From: Amanda Scholes on behalf of Planning.Responses
Sent: 11 December 2017 13:04
To: Planning Scanning
Subject: FW: Land at Pollards Nursery, Barnham

I have read Noise Assessment for Proposed Residential Development at Lake Lane, Barnham (Report No. JAE9392-REPT1-R5), dated 30 October 2017. Could you ask the applicant to reply to the following points please?

POLLARDS NURSERY, BARNHAM - SITE LAYOUT

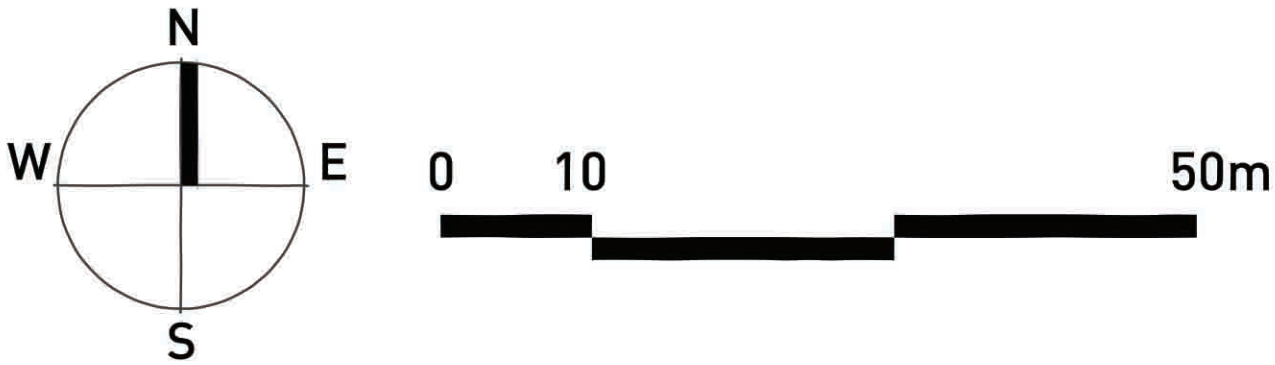
1. Is point LT2 actually on the northern boundary of the site? I am aware that the site layout has changed over time and I'm not sure that I've been looking at the most recent layout.

6. The report does not actually confirm that all dwellings are at least 15m from the boundary fence with the railway. Are they? Please could this be confirmed?
